Response to Planning Application

From: Arun District Council Greenspace

Application ref: P/49/21/RES

Location: Land North of Sefter Road & 80 Rose Green Road Pagham

Drawing No CSA/2038/126

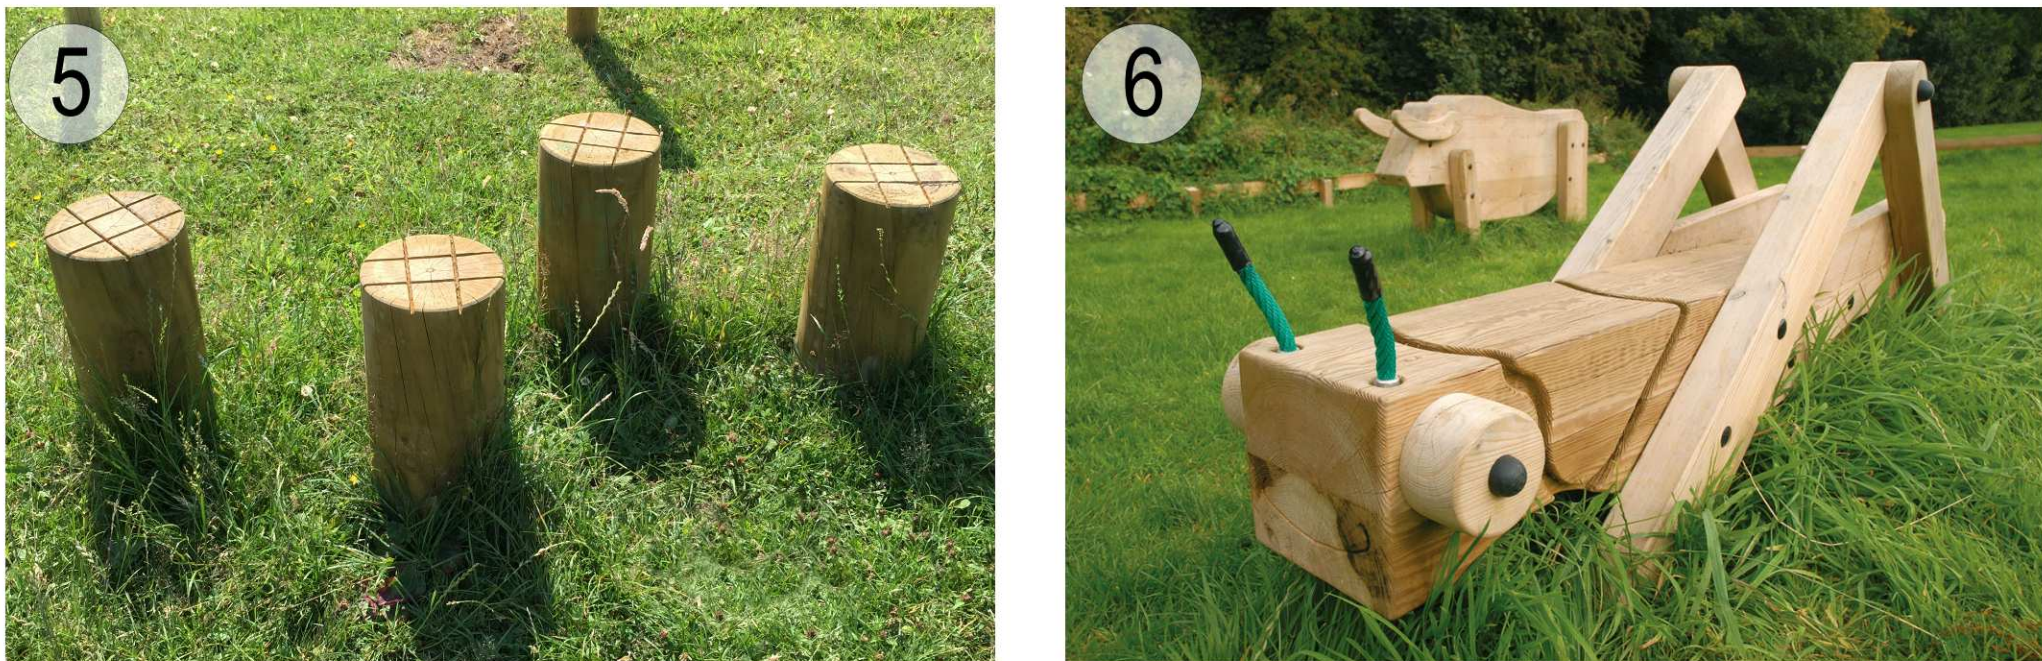
Previous consultation and 106 agreement had concluded in a requirement for an enhanced ELEAP catering for a minimum 8 play experiences and for there to be several LAPs located within the site. These are now shown and detailed within POS Dwgs CSA/2038/124 Rev B – LAP 1, CSA/2038/126 Rev B – LAPs 2&3, CSA/2038/128 Rev B – LAP 4. These LAPs appear to be well thought out, contain a good range of informal play and will be a valuable asset within the development. Detail has also been provided re the provision of the ELEAP within Dwg CSA/2038/139 ELEAP Playground Proposals. This detail has proposed a good play area offer containing equipment choice, surfacing, fencing and connectivity to the pathway network for the formal play.

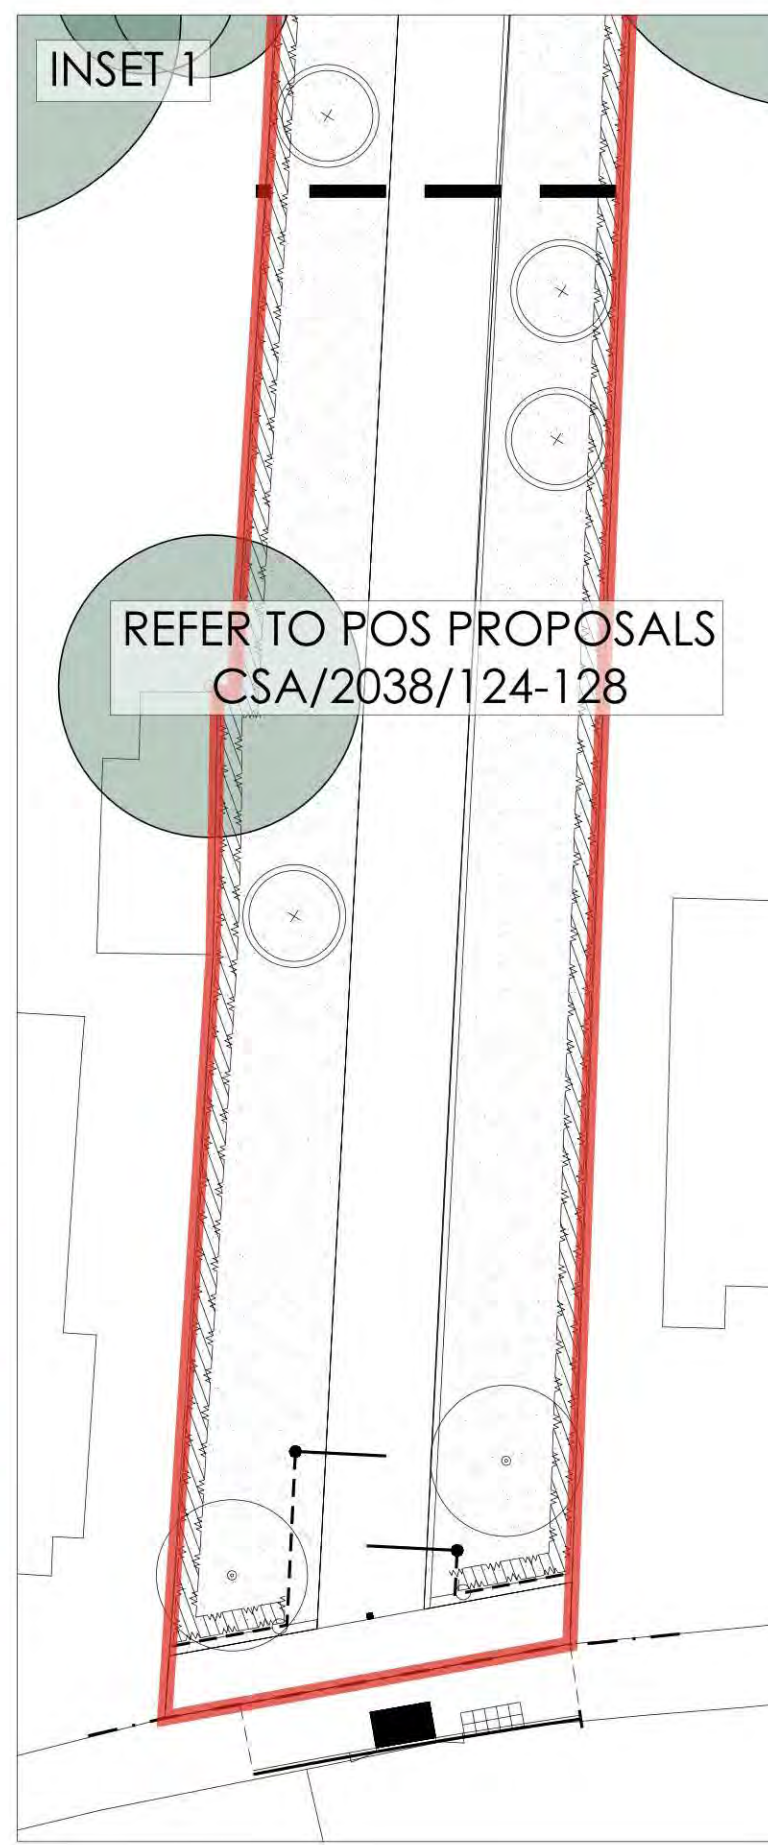
The submission of detailed information contained in the POS Landscape Proposals Sheets 1-5 of 5 Dwg nos CSA/2038/129-133 inc Rev B contain detailed POS, open areas, boundary and periphery buffer planting, marginal and pond treatments with trees and shrubs, wetland and grassed areas. These details would appear to be adequate for these areas, with sufficient detail given and proposing a scheme which would be suitable for location adding to biodiversity habitat as the scheme develops in these areas. A large proportion of the usable POS areas appear to the periphery of the site where buffer zones incorporate the existing tree presence. This is good to see and to be encouraged in an approach to retain and protect existing green features and the biodiversity habitat already formed in this area.

Soft landscaping has now been shown to the plot areas with the inclusion of a good variety of trees and shrubs to aid in the creation of sense of place, and the encouragement of biodiversity habitat. The Soft Landscape Proposals sheets 1-5 of 5 Dwg nos CSA/2038/129/Rev B have now provided the on plot landscape detail which was lacking on previous applications and provides the information in sufficient detail in plan form detailing species choice, actual quantities, planting densities and size at time of planting.
